**GEOTECHNICAL ENGINEERING
REPORT ADDENDUM**
Buttenwieser/Wiley Residence
6838 96th Avenue SE
Mercer Island, Washington

Project No. 200631 • April 26, 2022

City Comment Response Letter

File Nos. CAO21-007/SHL21-042/SEP21-027 – Buttenwieser/Wiley Residence
6838 96th Ave SE, Mercer Island, WA 98040; King County APN 302405-9010
Aspect Project No. 200631

TOPOGRAPHIC & BOUNDARY SURVEY
PARCEL NO. 3024059010
BUTTENWIESER / WILEY RESIDENCE
6838 96TH AVE SE
MERCER ISLAND, WA 98040

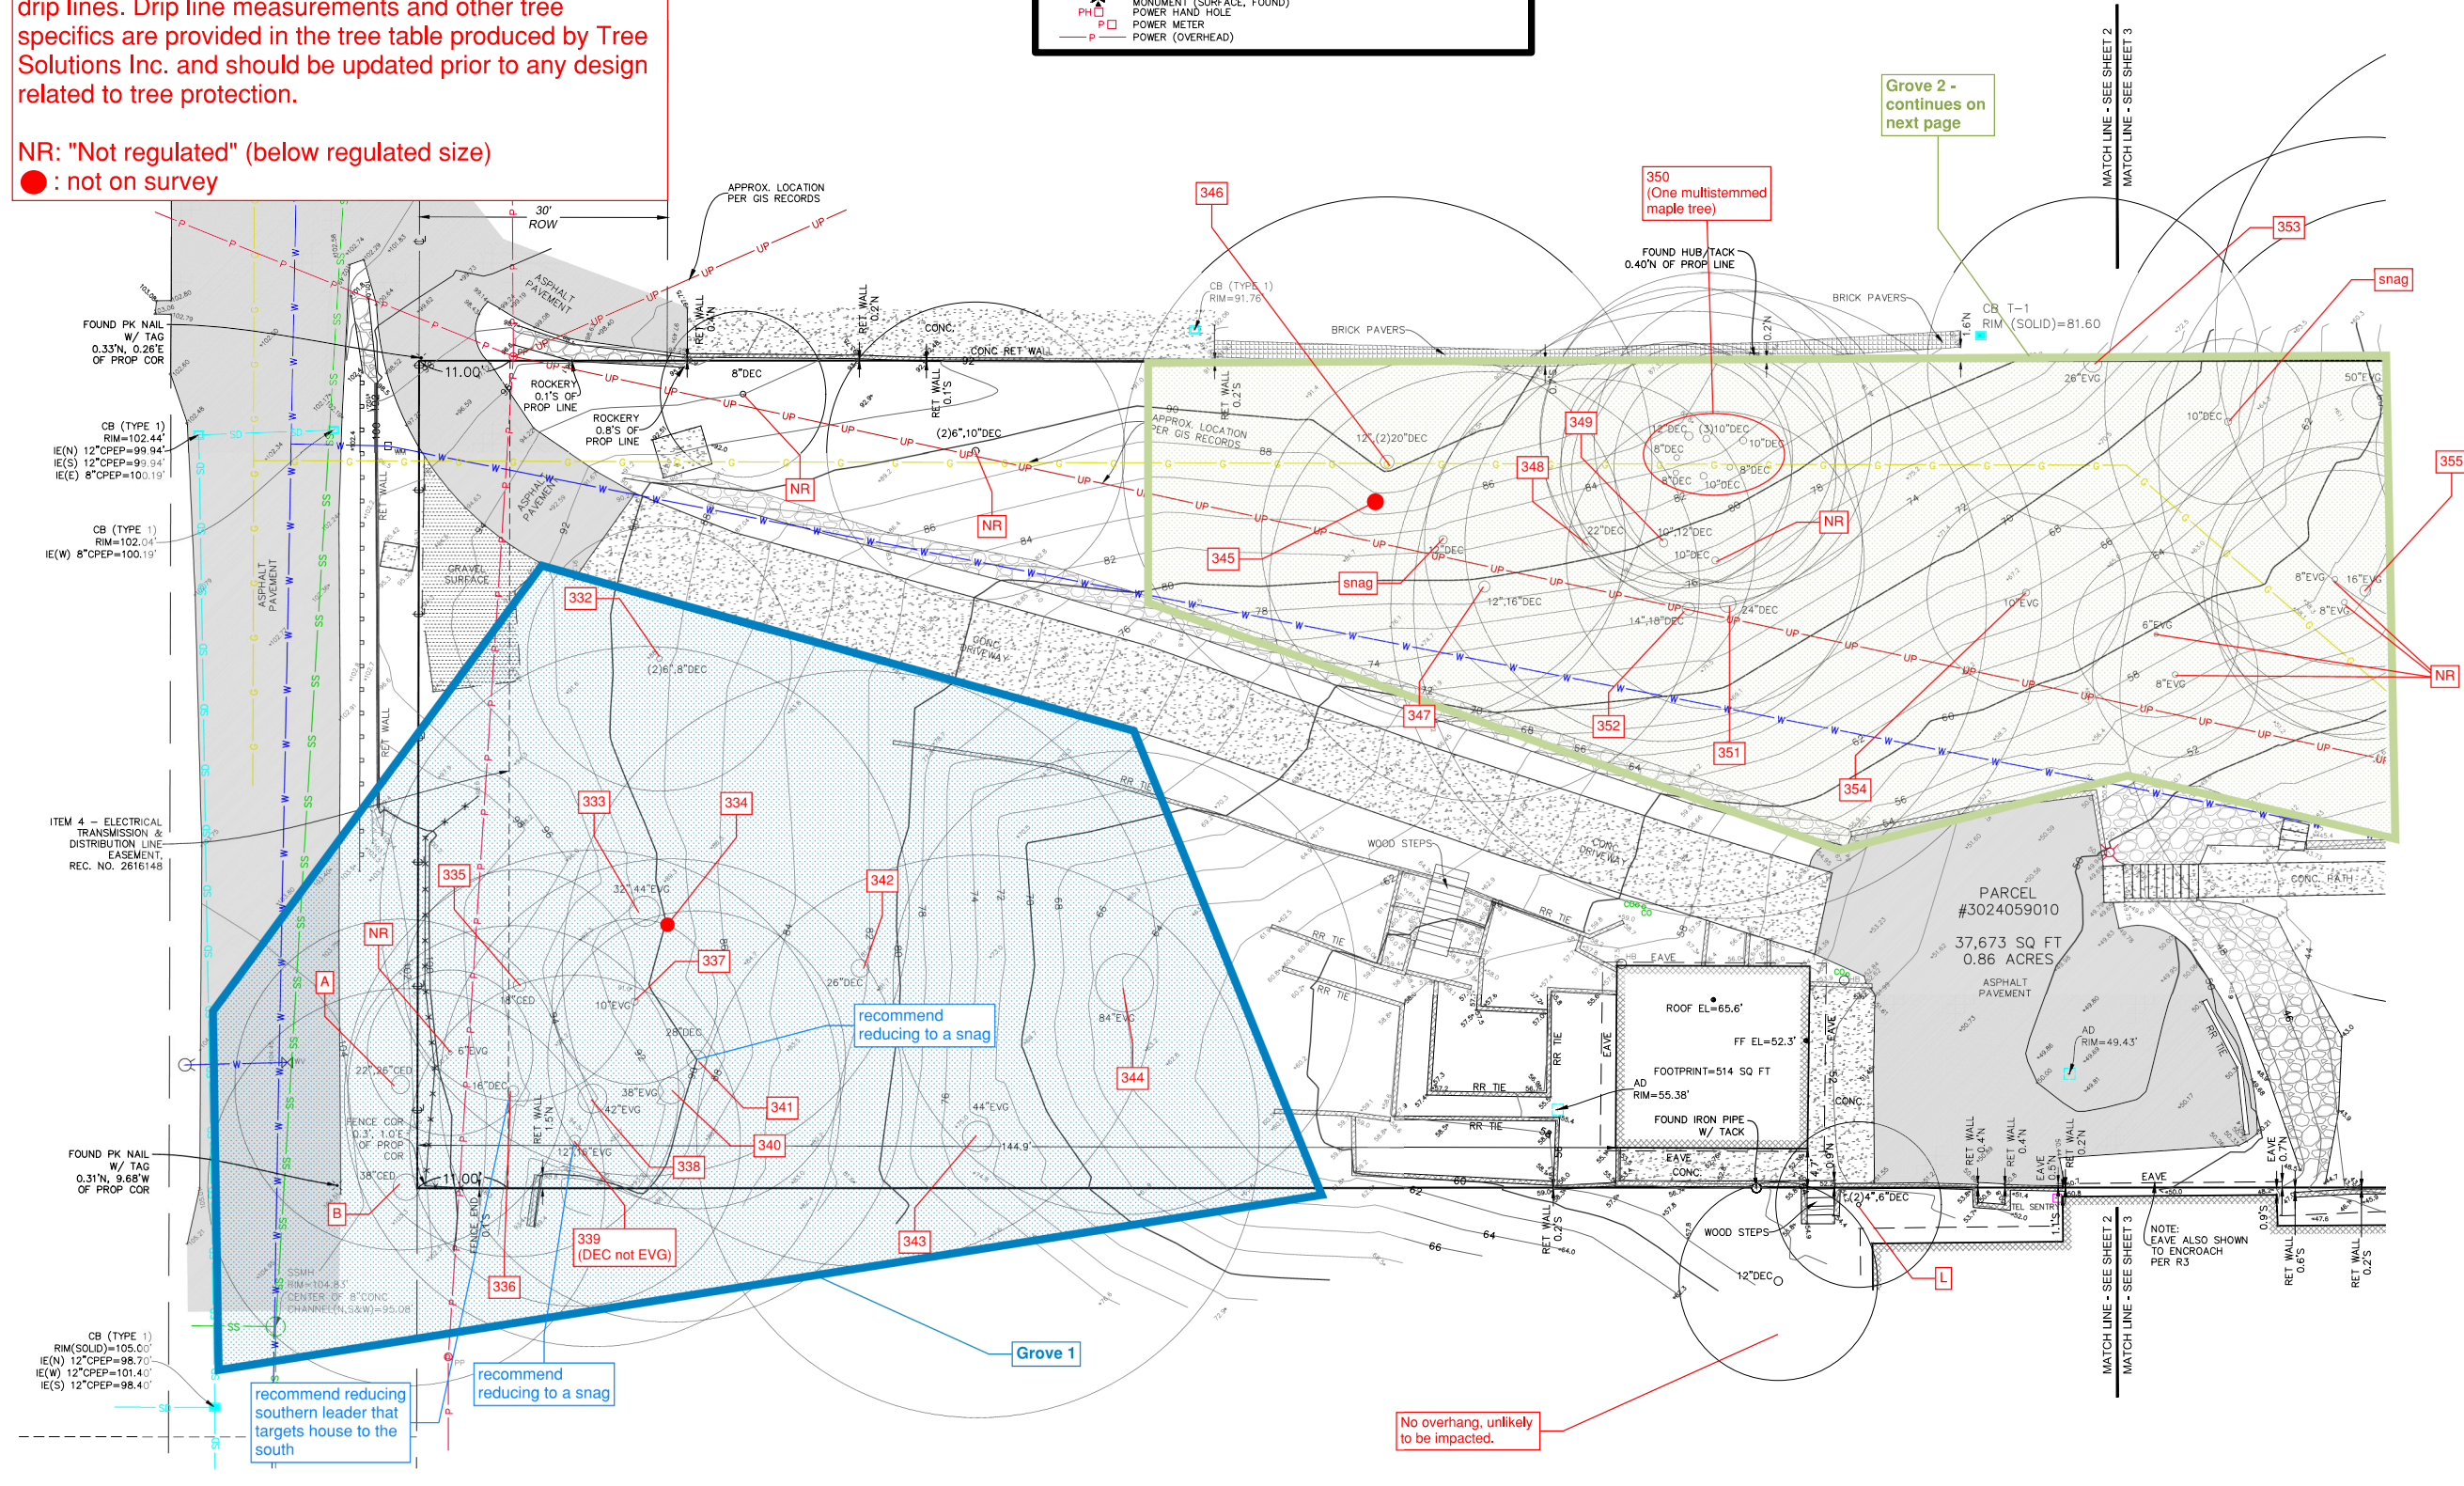
1. *Identify the locations, extents, and magnitudes of yielding conditions of existing retaining walls on a site plan. Include the location of the tree exhibiting response to slope creep discussed in geotechnical report section 2.1.3 on the site plan.*

2. *Specifically for the yielding retaining wall located northwest of the existing residential structure, indicate on a site plan, the location and extent of tension cracking in the soil or ground subsidence that is associated with this yielding condition. Indicate the cause of the yielding and whether the cause extends upslope.*

Aspect Response: We have included the requested information in our addendum.

Aspect Response: We have included the requested information in our addendum.
